Arun District Council
Arun Civic Centre
Maltravers Road
Littlehampton
West Sussex BN17 5LF
Planning & Building Control General Enquiries
Tel: (01903) 737756 Fax: (01903) 730442
Dx: 57406 Littlehampton
Minicom: 01903 732765
e-mail: planning@arun.gov.uk
website: www.arun.gov.uk/planning

Application No: FP/113/21/HH
Site Address: 14 Davenport Road Felpham PO22 7JR
Description of works: Hip to gable loft conversion with juliet balcony, alterations to fenestration/openings and external facade.

Thank you for your internet representation made on 19th June 2021 which has been recorded as an objection with the comments as follows:

Dwg No. 21009-P-107-D

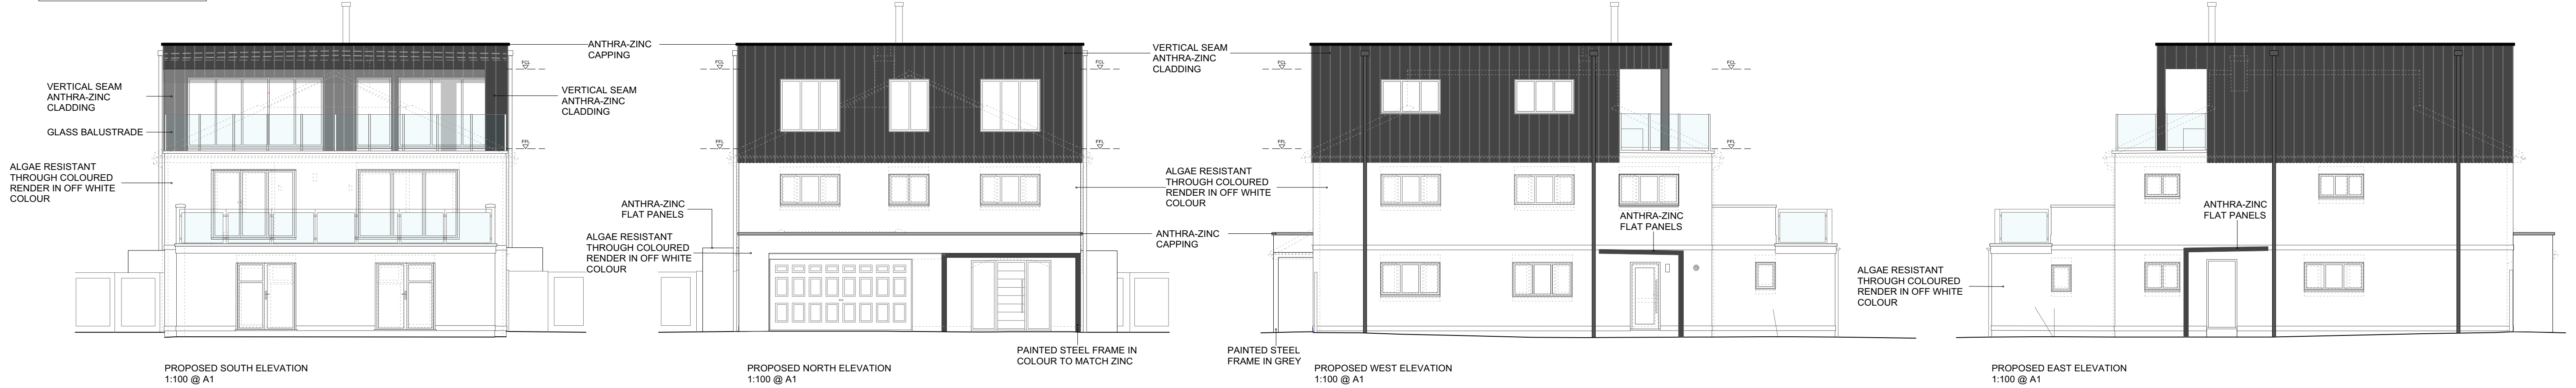
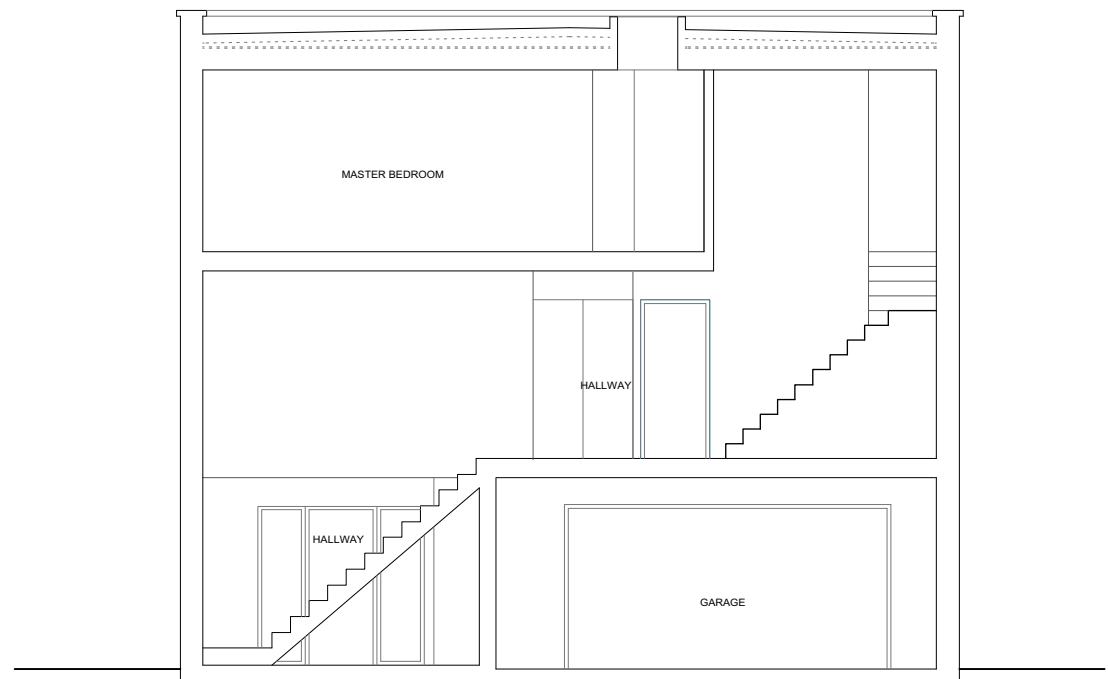
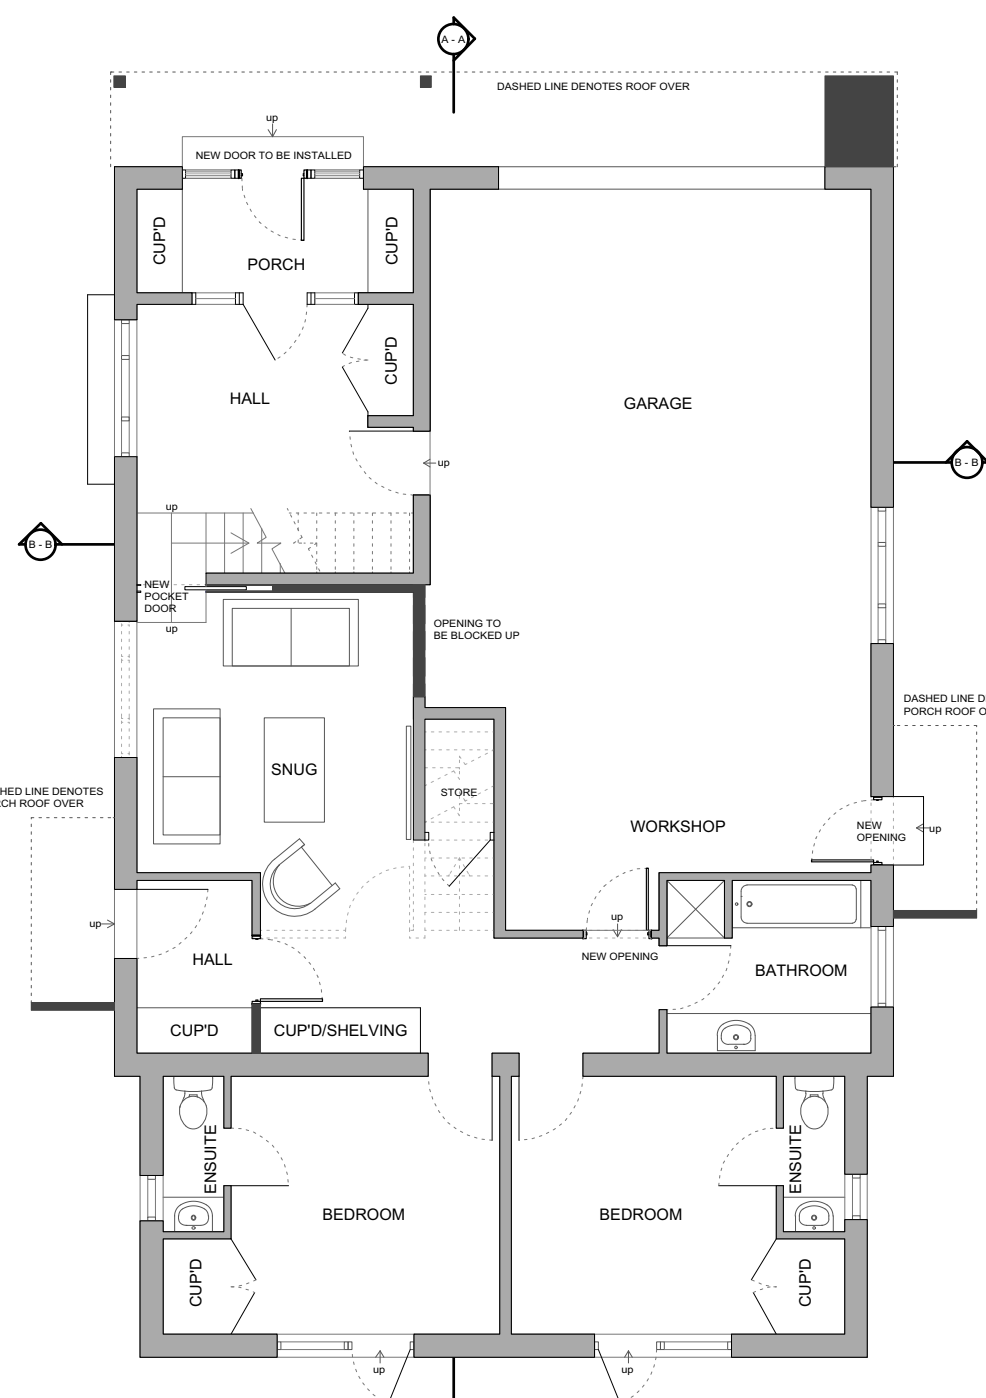
I note from the proposed plan that the proposed development is 1 meter above the current roof line, this and the design of the proposed building is not in keeping with surrounding and adjacent buildings, is unneighbourly, and is totally out of character with the Beach Estate development in general.
